City of Albuquerque Stormwater Construction Site Inspection Report

General Information							
Project Name:		Alameda Mixed Use					
Location:		Alameda and Signal					
Site Contact Name & Agency:		Gary Christensen - Snyder Construction	ESC File No.	C18E086			
		gchristensen@snyder-const.com	NPDES Id. No.	NMR1001TQ			
Inspection Date:		08/31/20	Start/End Time:	0910/0930hrs			
CoA Stormwater Inspector:		Timothy E. Sims					
Construction Phase:		sitework and vertical construction					
Type of Inspection:		<input type="checkbox"/> Regular	<input type="checkbox"/> Storm Event	<input type="checkbox"/> Post Storm Event >0.25" x	<input checked="" type="checkbox"/> 311/Complaint	<input type="checkbox"/> Follow Up

EROSION AND SEDIMENT CONTROL PLAN

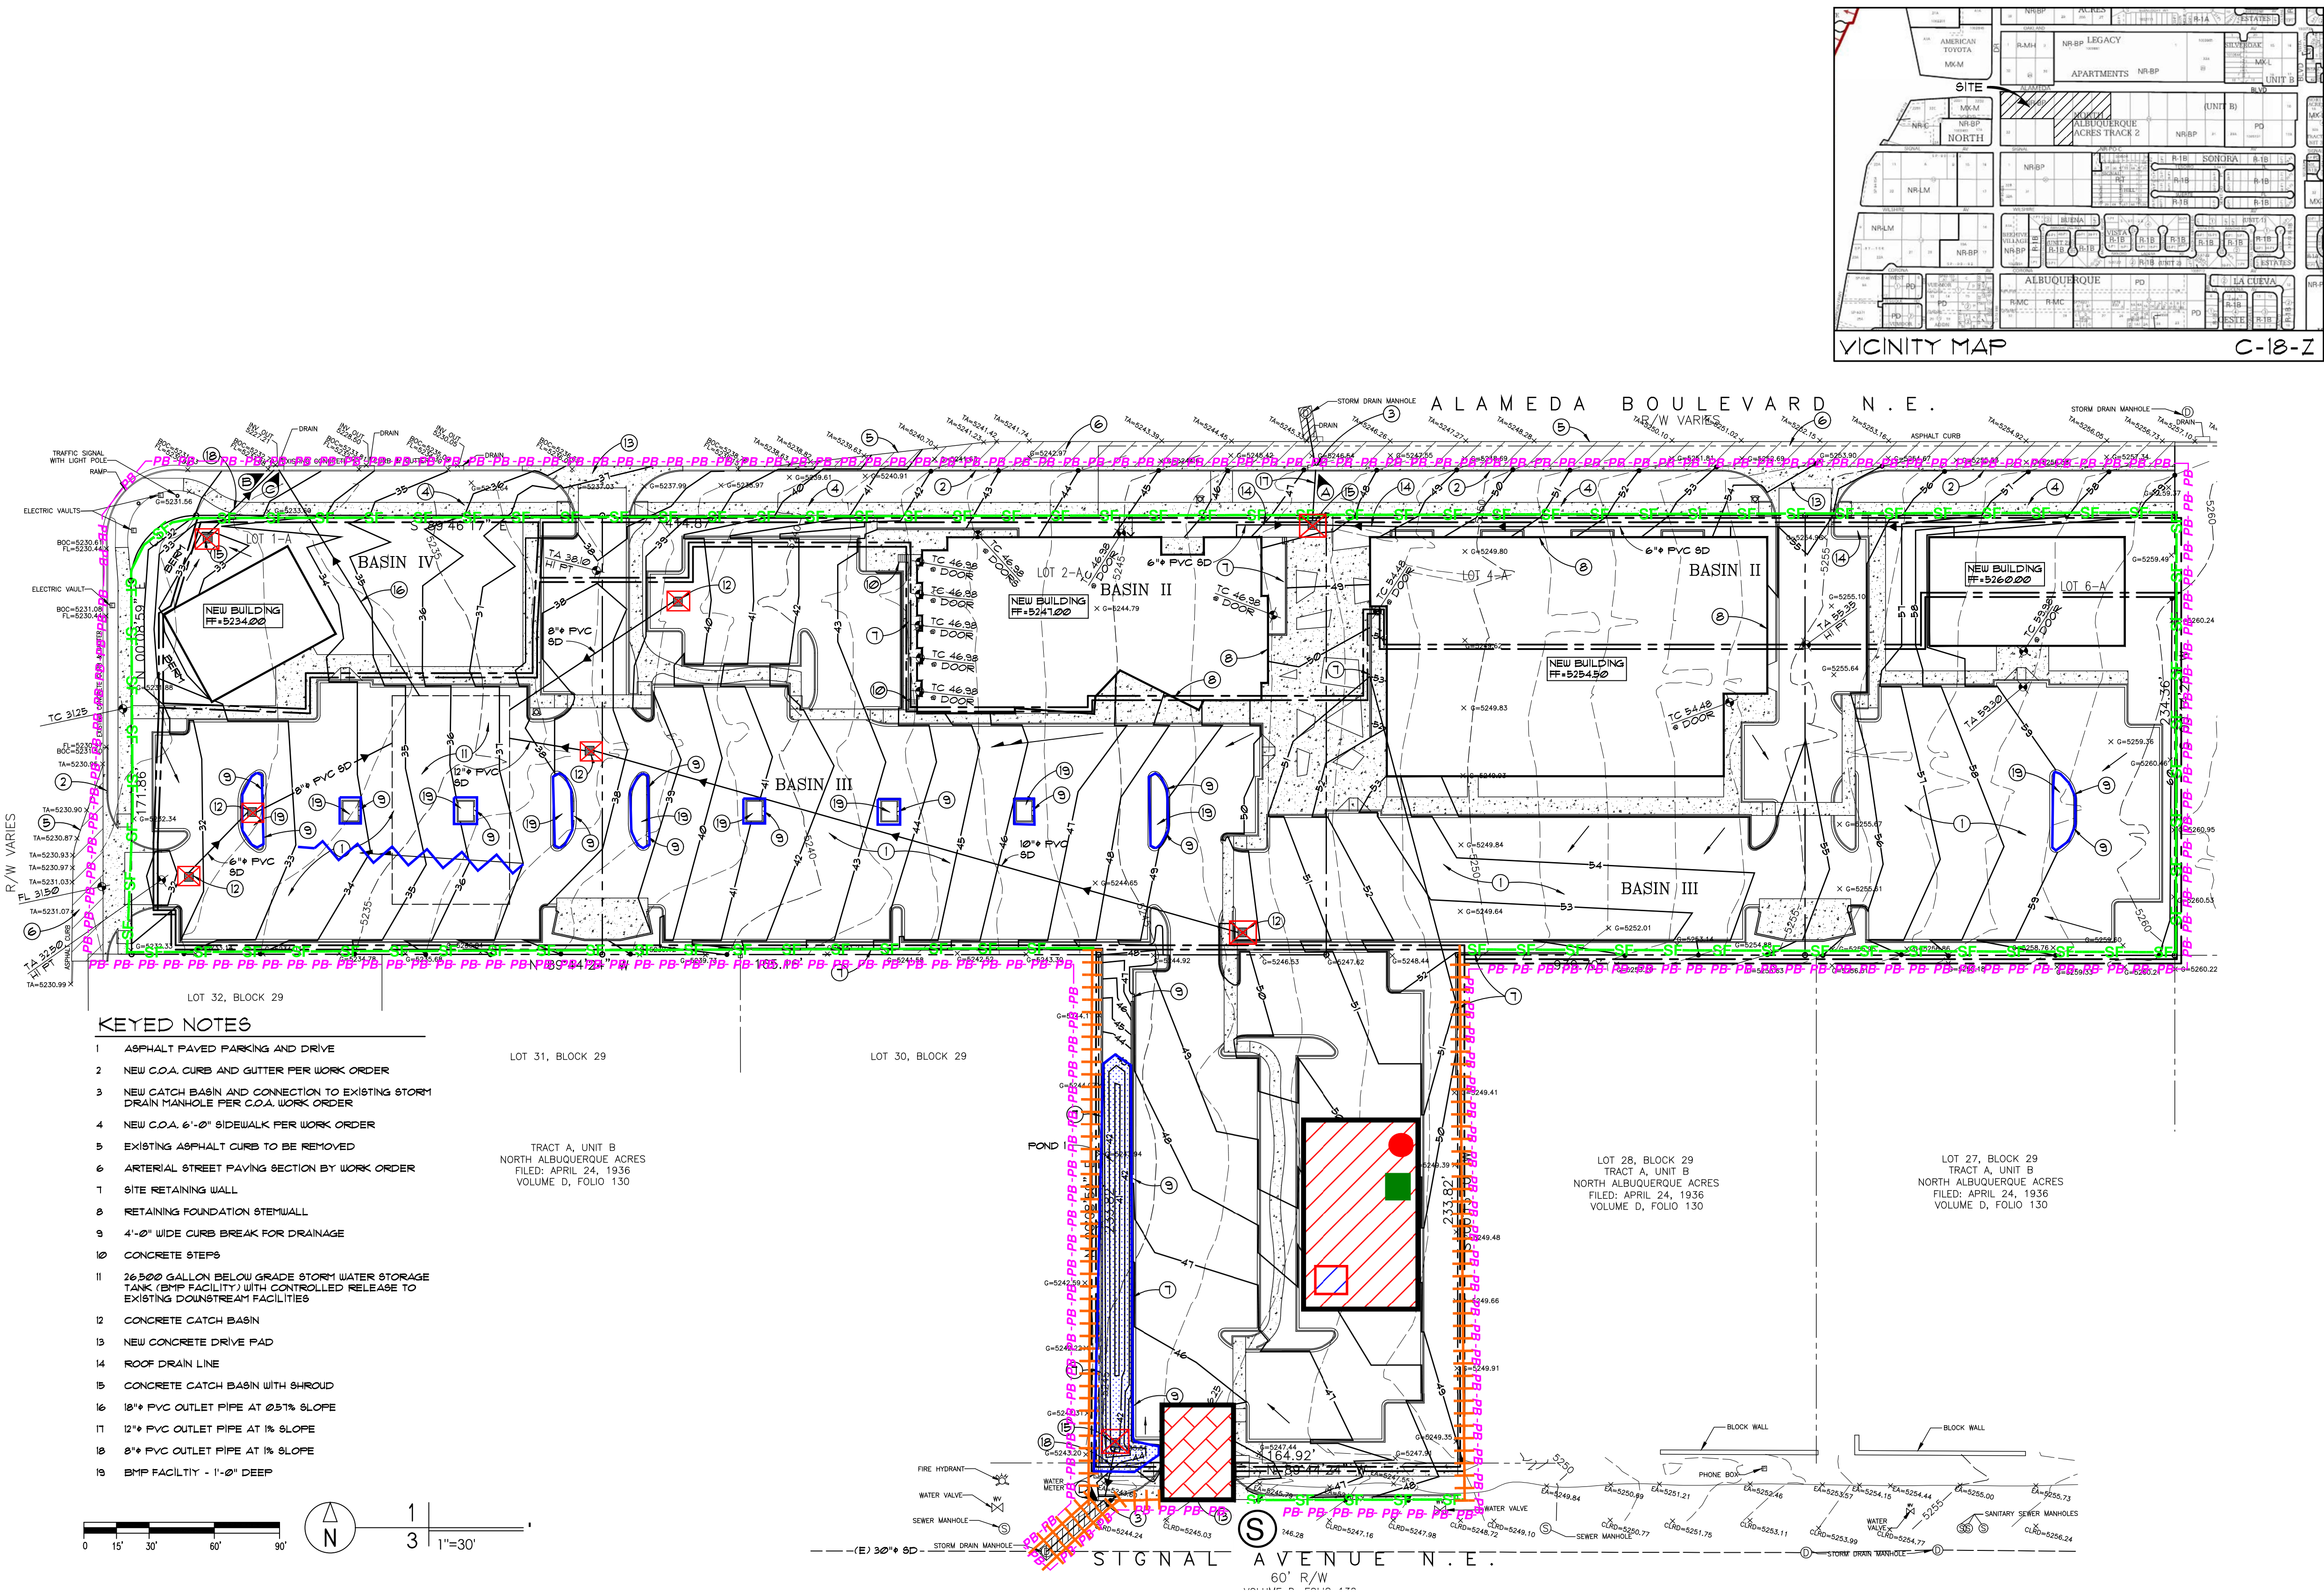
Item Number	Deficiency/ Corrective Action			
1	Silt fence is required on the NW pad site and ponding area. If construction has stopped for 14 days stabilization should occur per the General Permit			
2	Silt fence is required on the east pad site on the north and west sides. If construction has stopped for 14 days stabilization should occur per the General Permit.			
3	Inspection reports are required until final stabilization has occurred.-(Thanks for the reports)			
2.1	Discharge off site? (Y/N)	No		
4	Self Inspection Reports		Latest report Date:	8/31/2020
